DRB Application No.: 06DRB-00094 (D&F)  
Project Name CRYSTAL RIDGE SUB UNIT 3  
Agent: Wilks Company

**DRB CASE NO/PROJECT NO: 1002189**

**RE: Crystal Ridge Subdivision, Unit 3/ p&f**

PURPOSE OF PLAT:
 THE PURPOSE OF THIS PLAT IS TO DIVIDE LOT 1-P-1 INTO TWO (2) LOTS AND GRANT ANY EASEMENTS AS SHOWN.

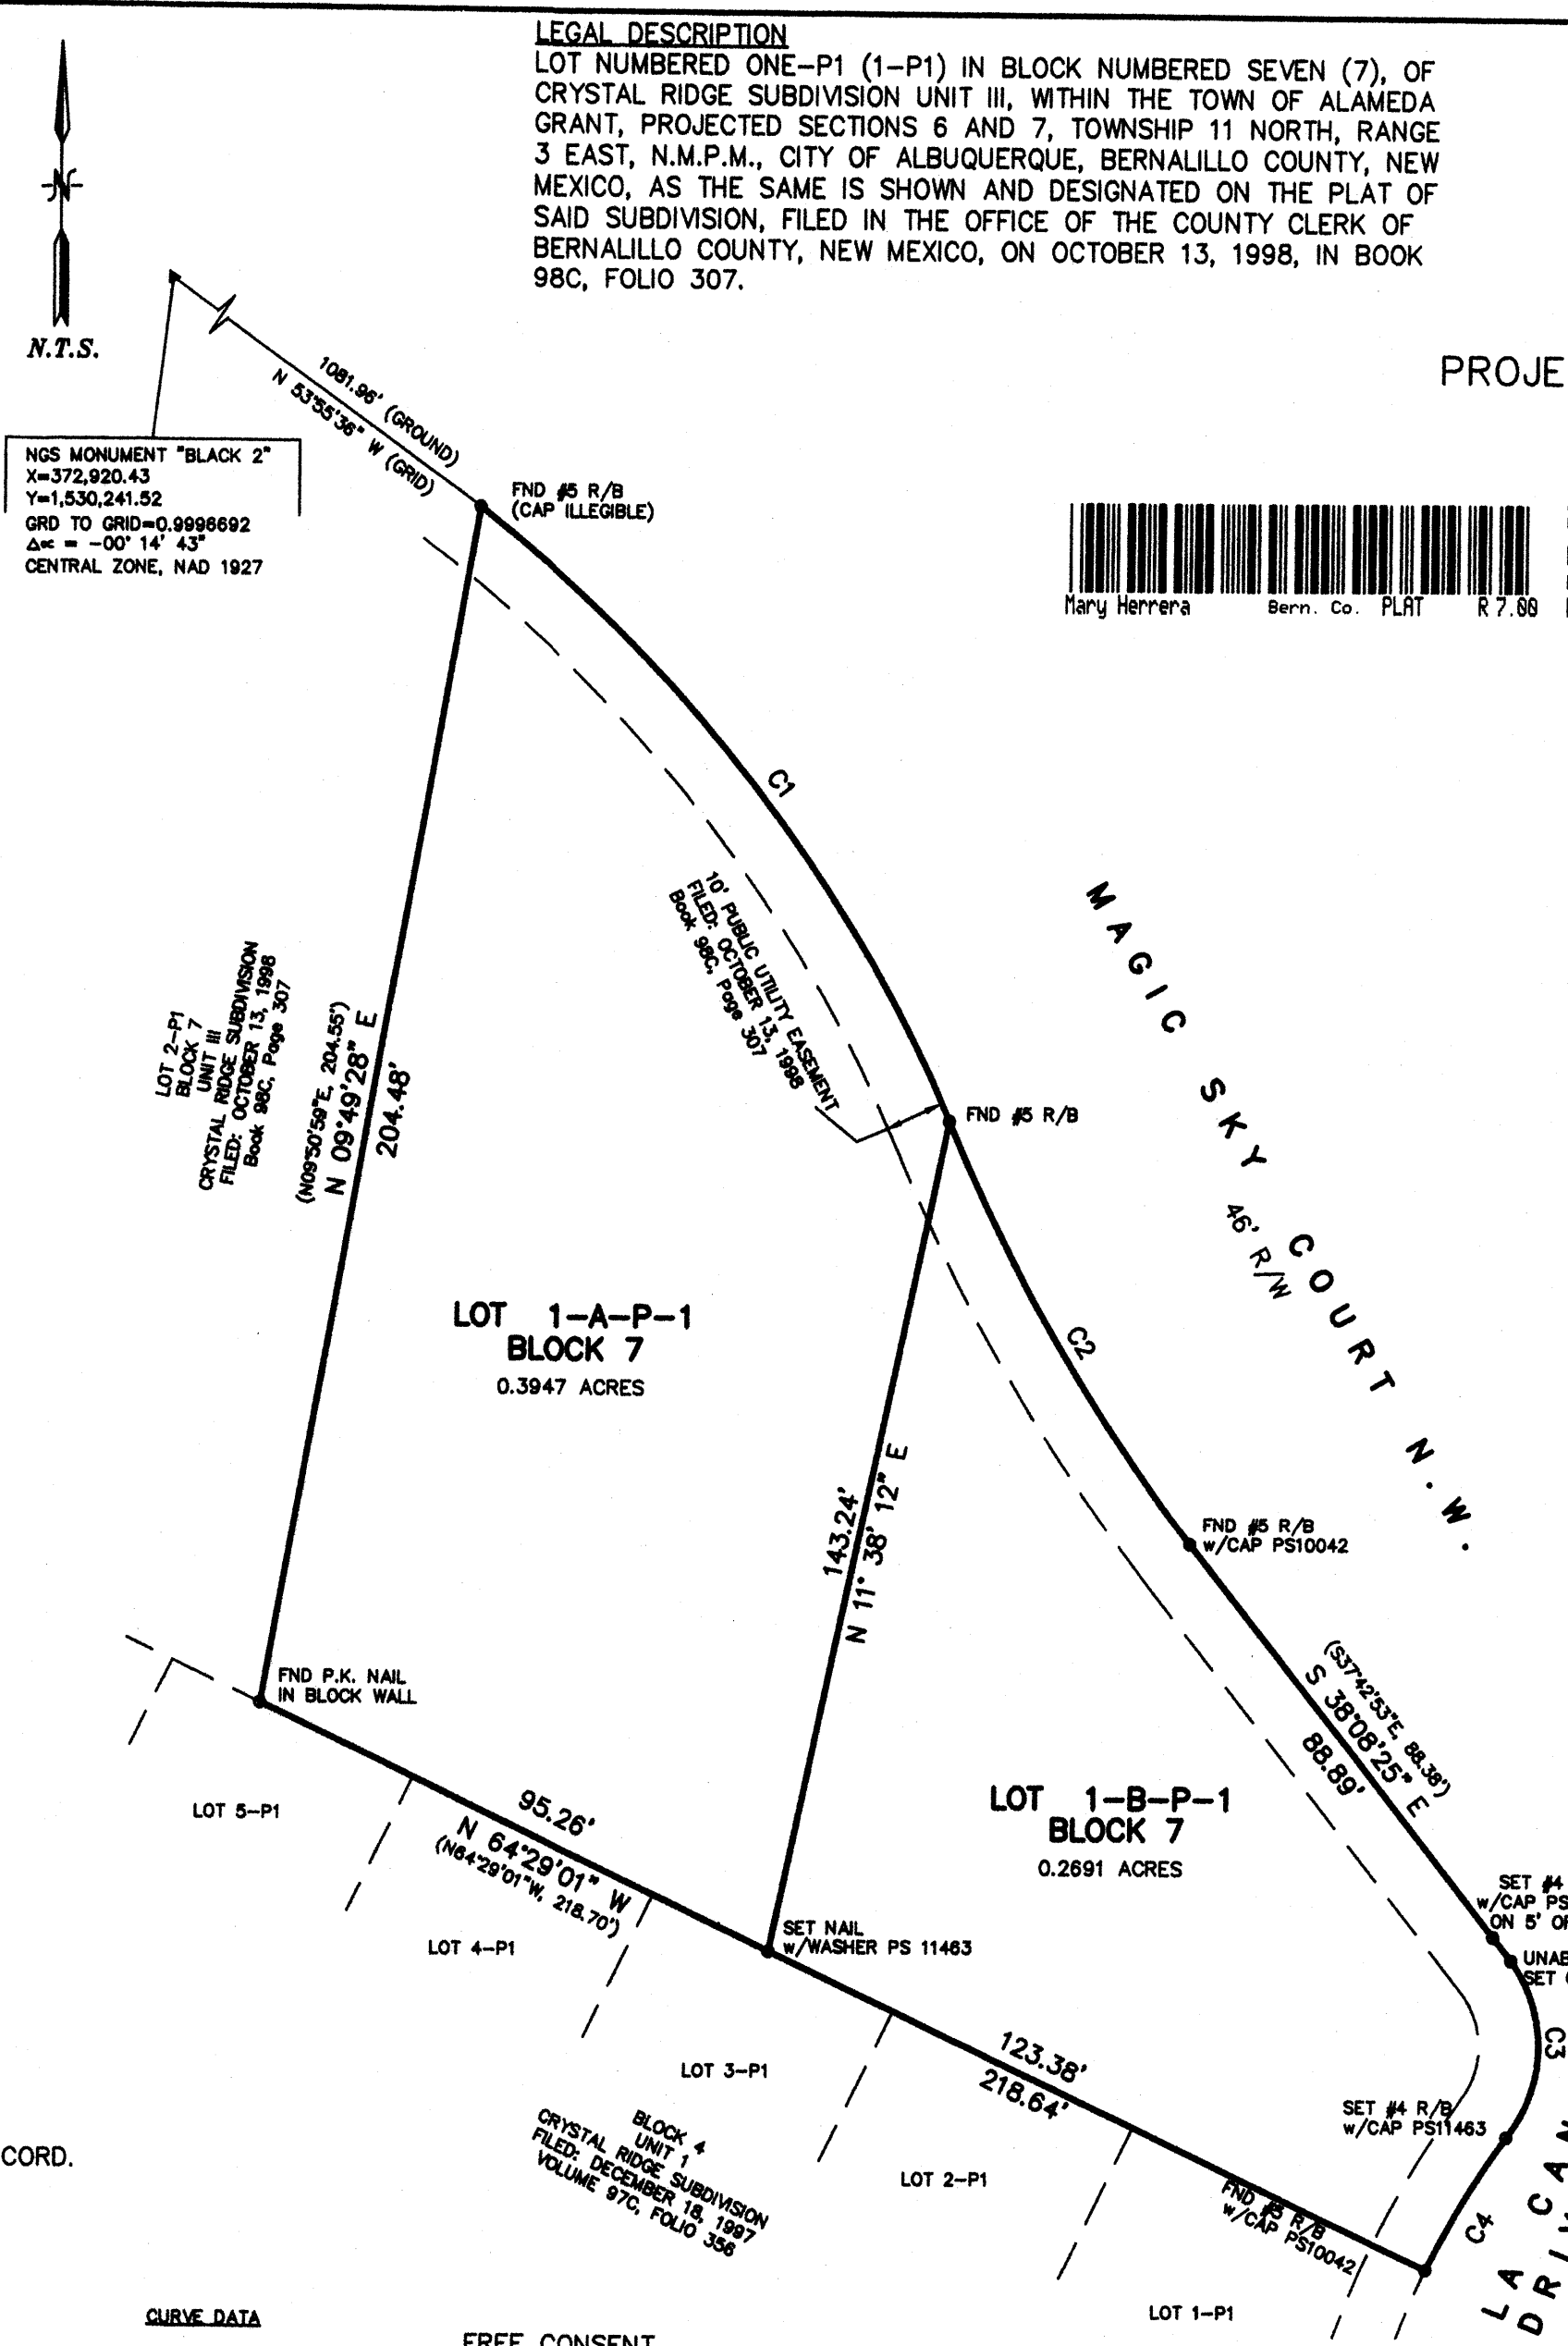
Probably need a cross lot drainage easement.
